# Memo.

**Date:** 10<sup>th</sup> February 2012  
**To:** Sarah Smith  
**Cc:** -  
**From:** Oliver Waring  
**Subject:** N6/2010/3120/DC3 – Redevelopment of site to provide a wet play area, adventure play areas, an educational play area, high ropes attraction, changing huts, education room, cafe and toilet facilities.

An assessment has been made of the impact of the above proposed development on trees on or near the proposed site.

PROPOSED BOUNDARY FENCE DETAILS
2.0m WATER PLAY PARK
3.0m HIGH ROPES AREA
SCALE - 1:25

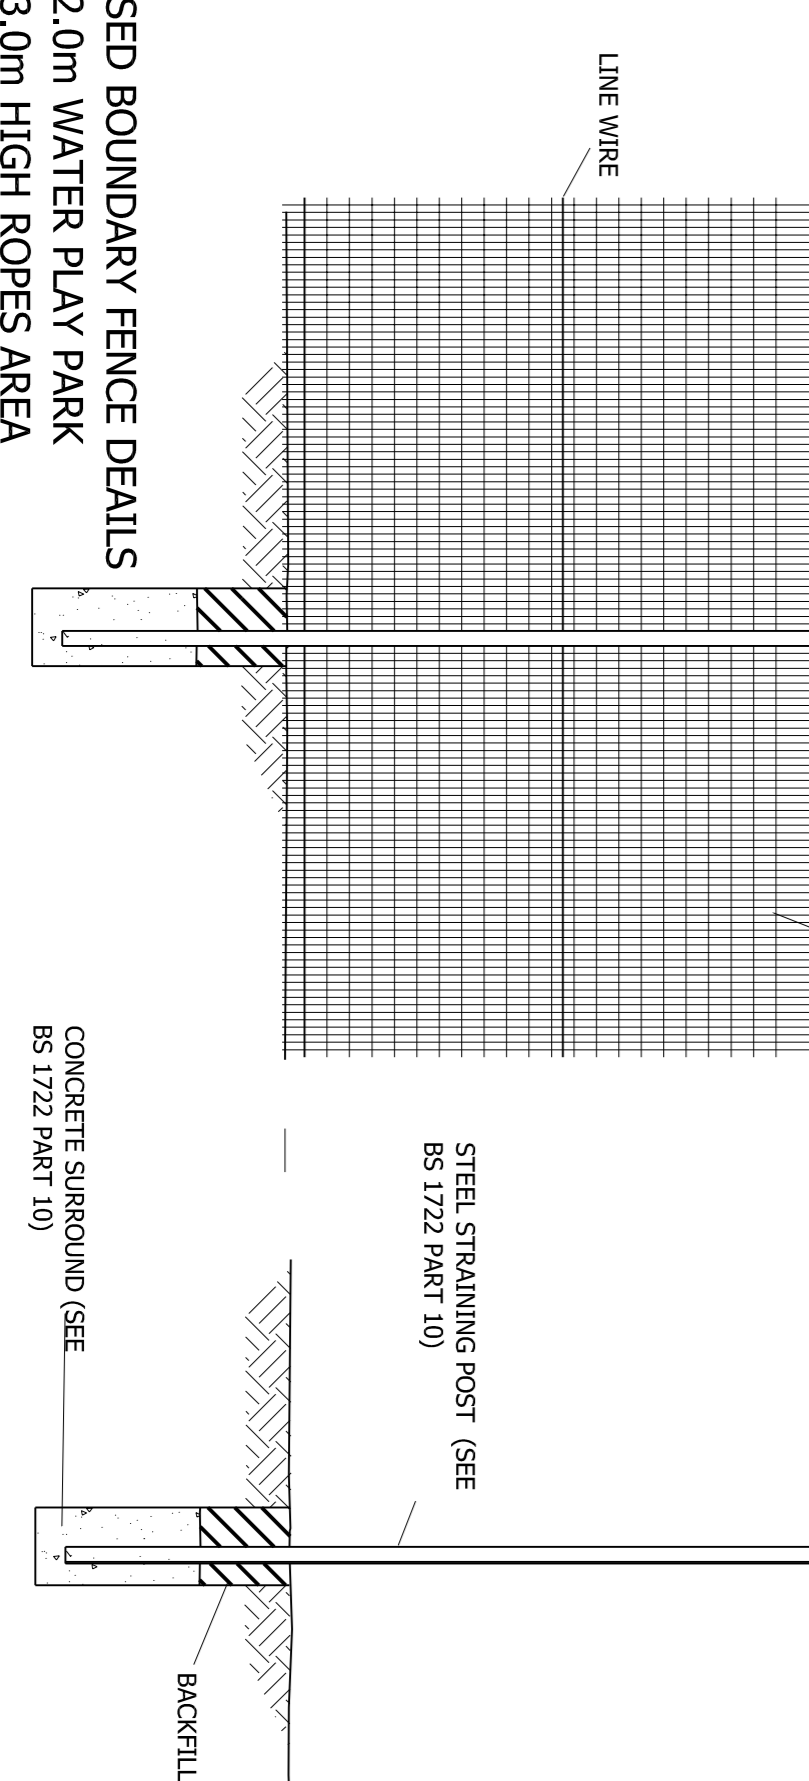
The high rope access area is shown as having a metal fence all the way around it. The northwest section of the proposed fence is shown running along the edge of a woodland section. It is very close to the stems of some of the trees in this section. It would be better to move the fence between a 1m-2m away from the trees. This would require less pruning of the trees (needed to facilitate the erection of the fence) and will discourage people from climbing the trees and climbing over the fence. Also the surface proposed for the high ropes is shown as bound gravel surface. This type of surface is not ideal close to the trees and their rooting area and I would rather see something like bark mulch in this area.

- The Arb report and the proposed plans need to correlate, specifically with regard to tree removals. It would be helpful if the reasons for removal were supplied i.e to facilitate development or because of poor condition. (At the moment I have to guess the reason for removal if it is not obvious).
- The root protection barrier information is not helpful. A more thorough explanation of why it is there would be useful. Again this information does not correlate to the arb report.
- The fencing around the high ropes section is too close to the trees and should be moved away from the wooded area to the northwest of the proposed development site.
- The bonded gravel surface within the high ropes area is not appropriate I would recommend a bark chip over a permeable membrane.
